**KIRKLEES METROPOLITAN COUNCIL
INVESTMENT & REGENERATION SERVICE**

**DELEGATED DECISION TO DETERMINE APPLICATIONS FOR
NON-MATERIAL AMENDMENTS**

Reference No: **2025/NM/92805/E**

Site Address: Hopton Mills Cricket Club, 18, Woodbottom, Lower
Hopton, Mirfield, WF14 8HG

DRAWING TITLE: AS PROPOSED

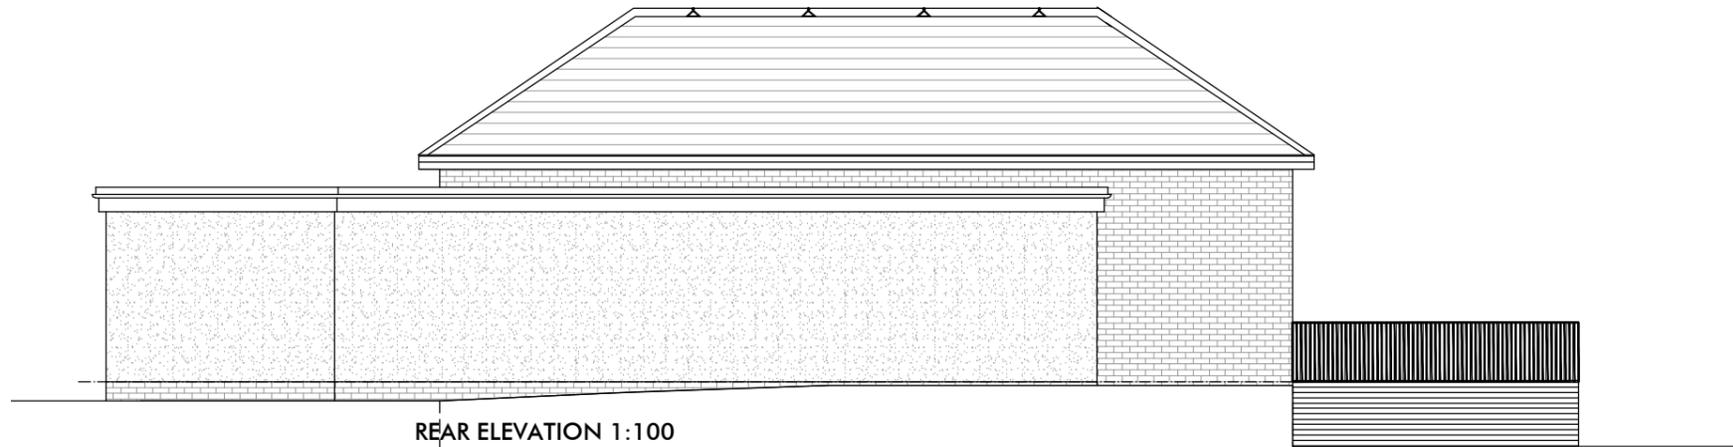
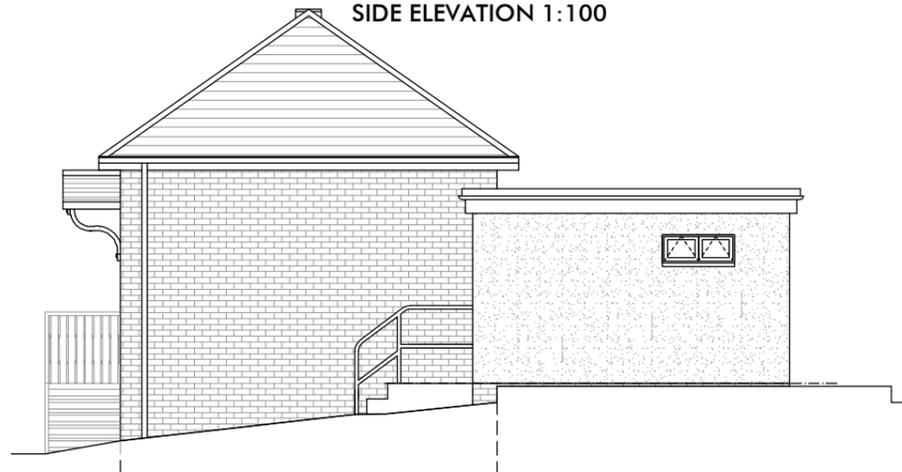
The amendment seeks to amend the shape of the extension by infilling sections of the extension approved under 2025/90202, reduce the height of the roof and change the internal layout of the building.

Amendments sought will increase the footprint of the extension by 13.55m² and alter the internal layout of the building.

The internal layout of the building will be altered to increase the floorspace of the public area, thereby increasing its capacity. Under application 2025/90202, KC Environmental Health raised concerns regarding potential noise emissions from the building. At that time, officers considered the proposed increase in floorspace acceptable. However, any further increase would require an additional noise assessment to ensure that neighbouring occupants are not adversely affected.

The proposal /would result in a material increase in scale, width and depth of the building.

The amendments would result in an increase in size, scale and changes to the internal layout of the building which would result in material changes to the application. The proposed amendments need to be assessed further in respect of NPPF paragraph 154b, and Local Plan Policy LP24, LP52 & LP56, they therefore do not benefit from an application for the non-material amendment application process. The applicant may wish to apply for these changes under a S73 application.

A full assessment of NPPF paragraph 154b, and Local Plan Policy LP56 & LP24 should be undertaken through a Section 73 application.

On the basis of the above, the proposed change would not be acceptable under the non-material amendment procedure and as such is recommended for refusal.
